This objection refers only to the following part of the application

'The demolition and erection of a replacement boundary wall and fence' These works have already been completed at 52 Gledholt Road HD1 4HR

**Site Plan**  
1 : 100

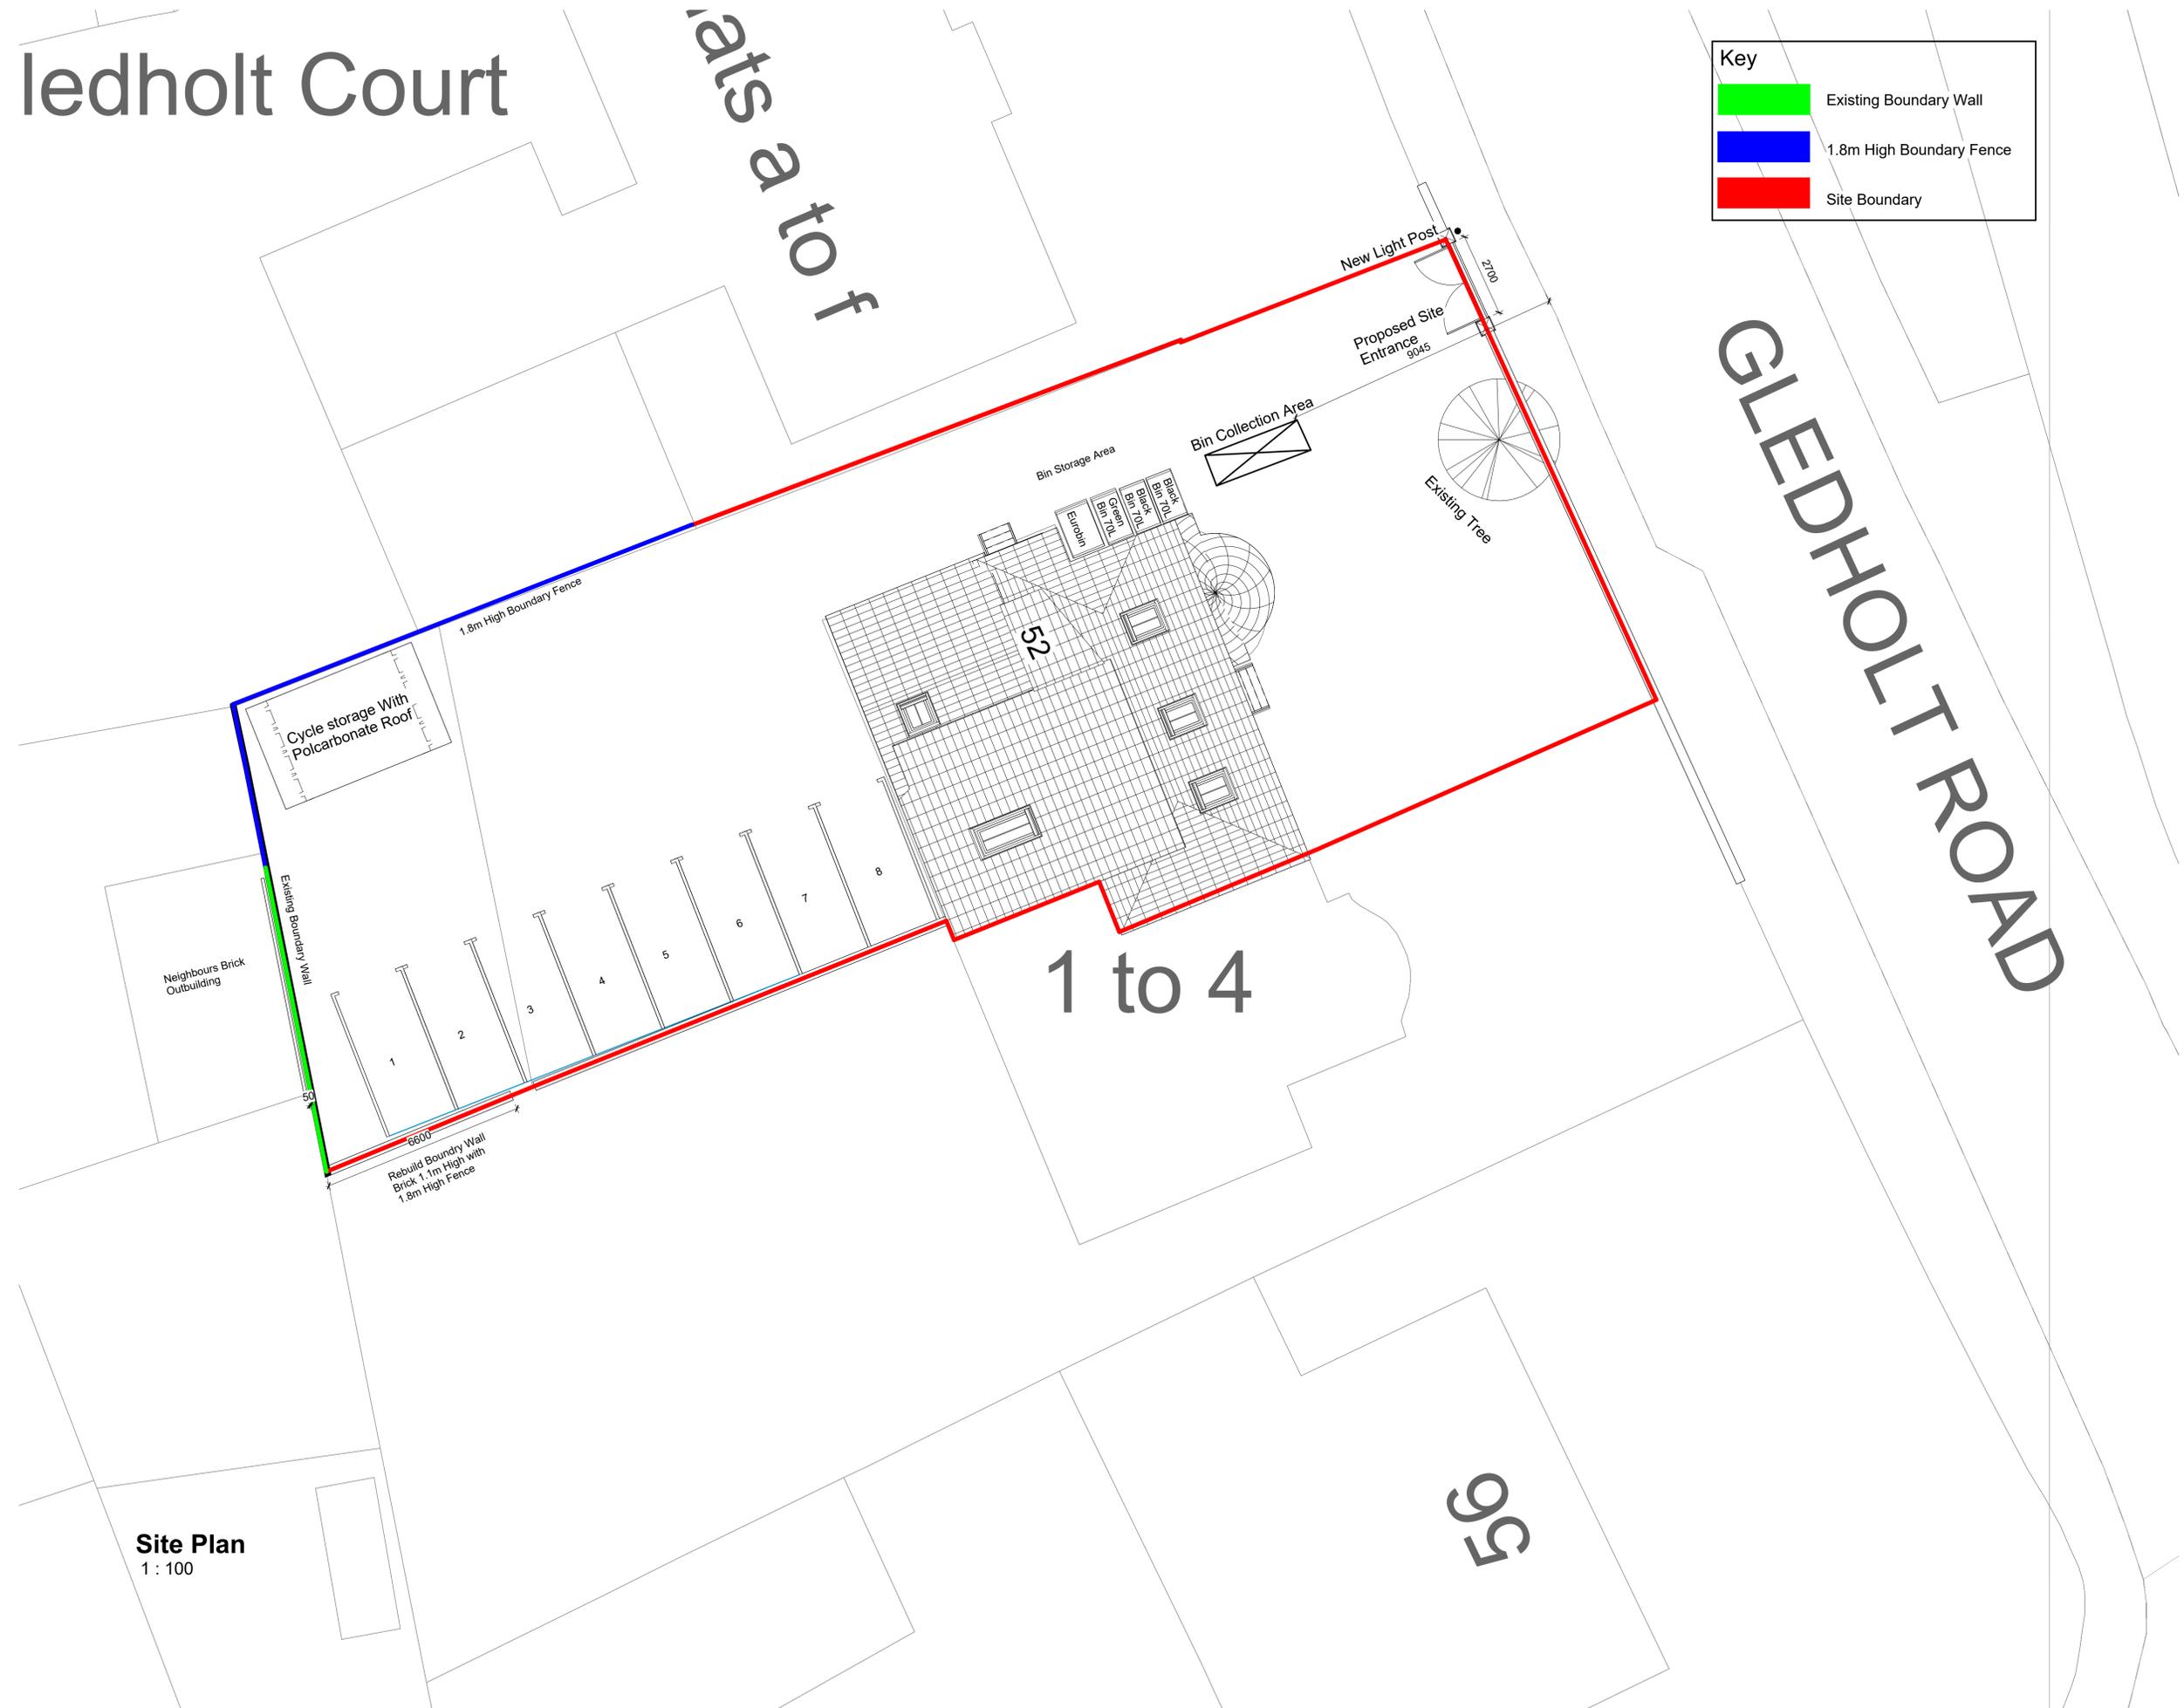
'The height of the boundary wall will remain the same' The original rear wall was approximately 11 feet tall and the replacement is only approximately 6 feet tall. The original wall was of solid brick construction and it is now a wooden fence, through which it is possible to see into my back garden and across this into my property. Since the height of the boundary fence is significantly lower than the original wall, I feel the security of the rear of my property is significantly negatively affected.

This may be true regarding the redevelopment of the building at 52 Gledholt Road, but the associated works namely the changes made to the boundary wall will significantly impact upon the privacy and security enjoyed at my property,

The privacy and security, which I was previously afforded by the brick wall is now significantly impacted upon and consequently the amenity enjoyed is not as it was before the works were begun.
